**For Approval of the Railway (Metrolink – Estuary to Charlemont via
Dublin Airport) Order [2022]**

ABP-314724-22

ORAL HEARING

MetroLink Oral Hearing –
Schedule of Proposed Changes, Modifications or Updates

Sheet 01 of 02

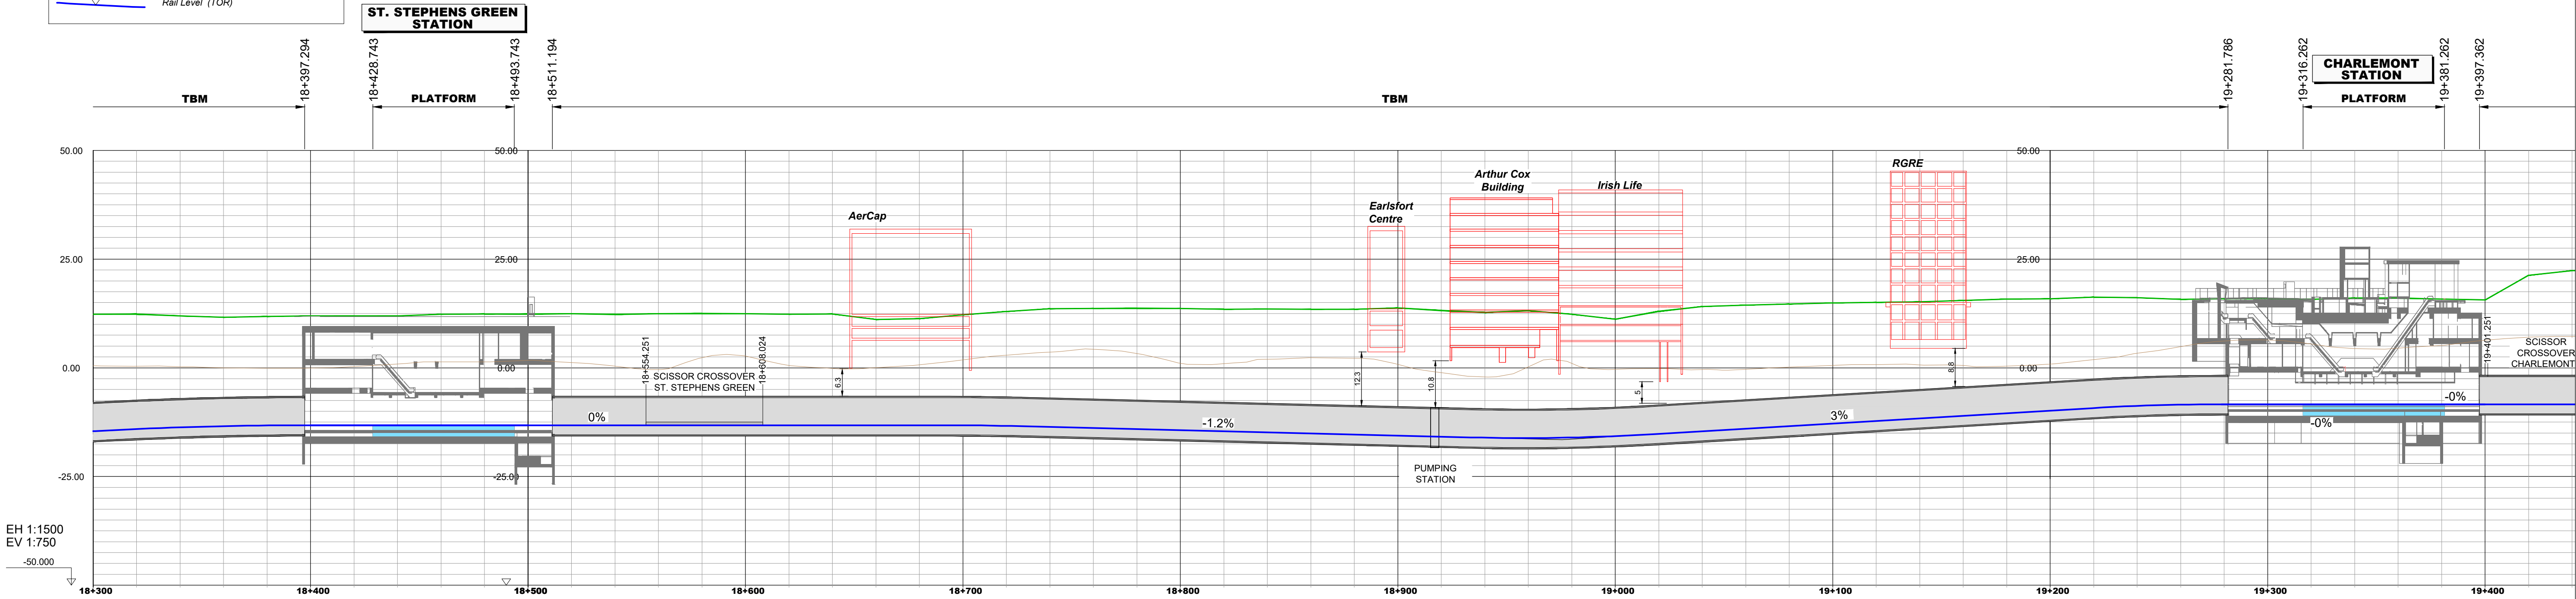
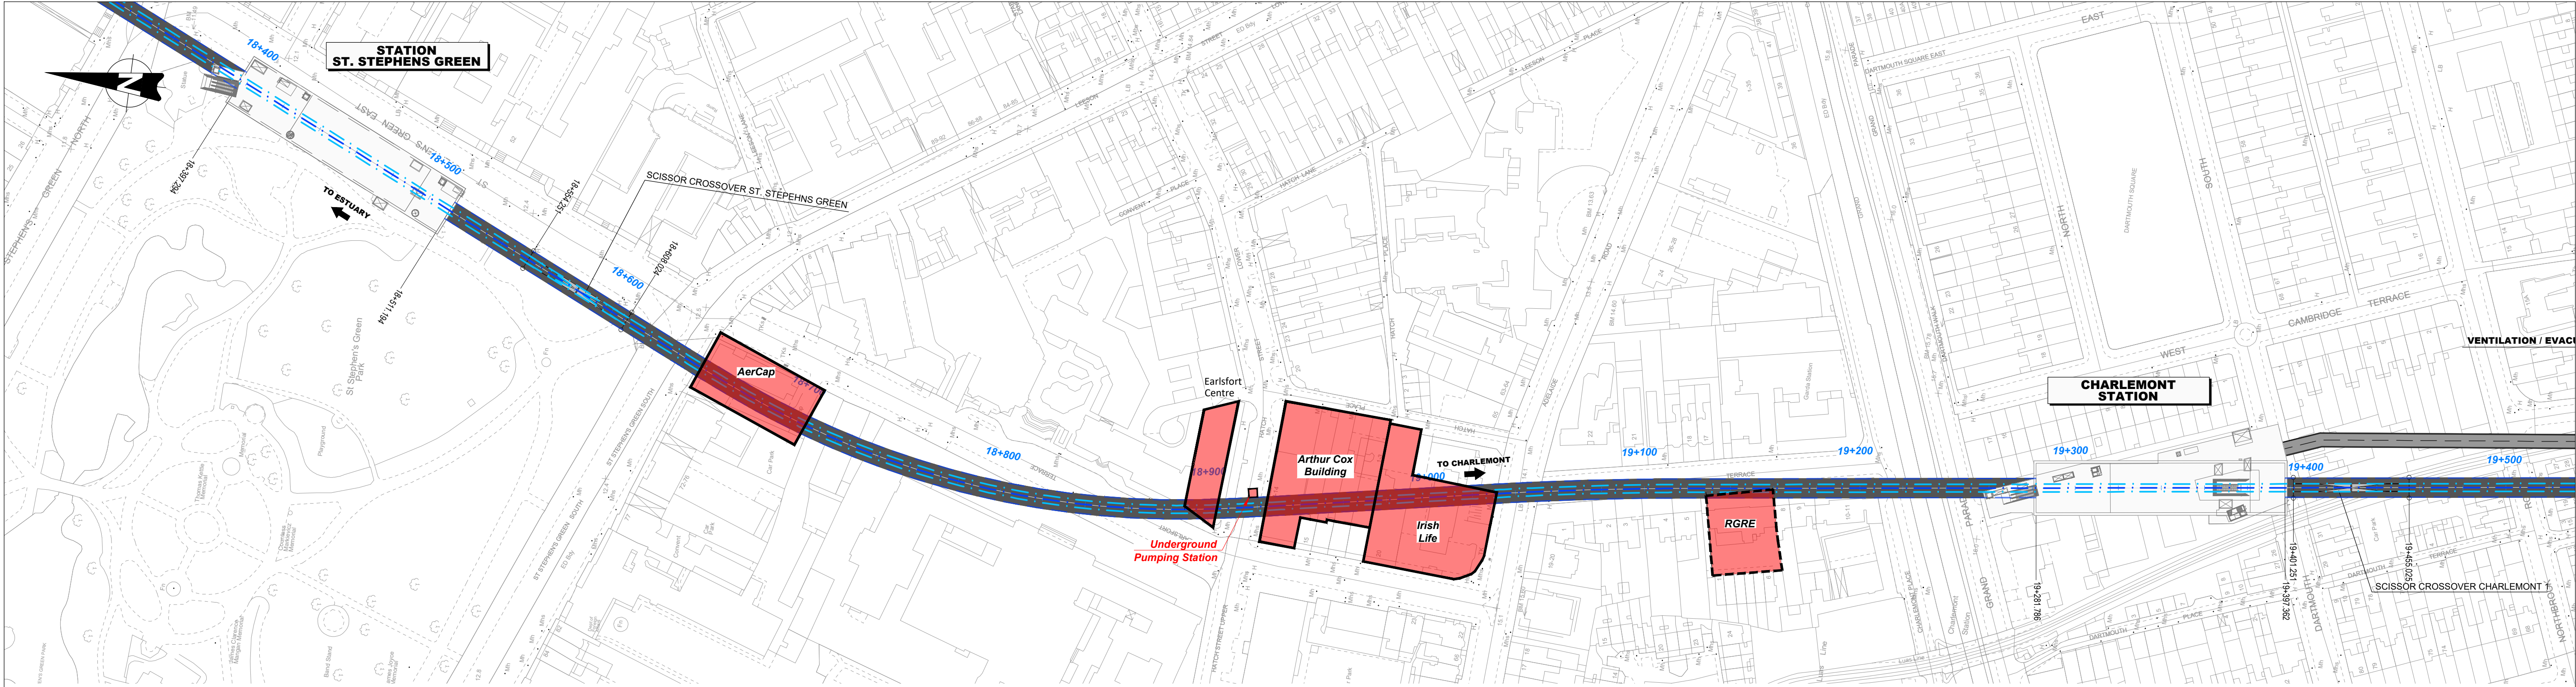
Item No.	Document Title	Reason for Proposed Change, Modification or Update	Proposed Change, Modification or Update Required
64.	Tunnel Alignment Saint Stephen's Green_Charlemont RO Application Alignment and Deeper Vertical Alignment Option 2 Sheets_Drawing Number ML1-JAI-RTA-ROUT_XX-DR-Y-01027	In response to/ additional information for the Inspectorate	Drawing furnished to Inspector on Monday 4 th March 2024 and available on www.metroinkro.ie
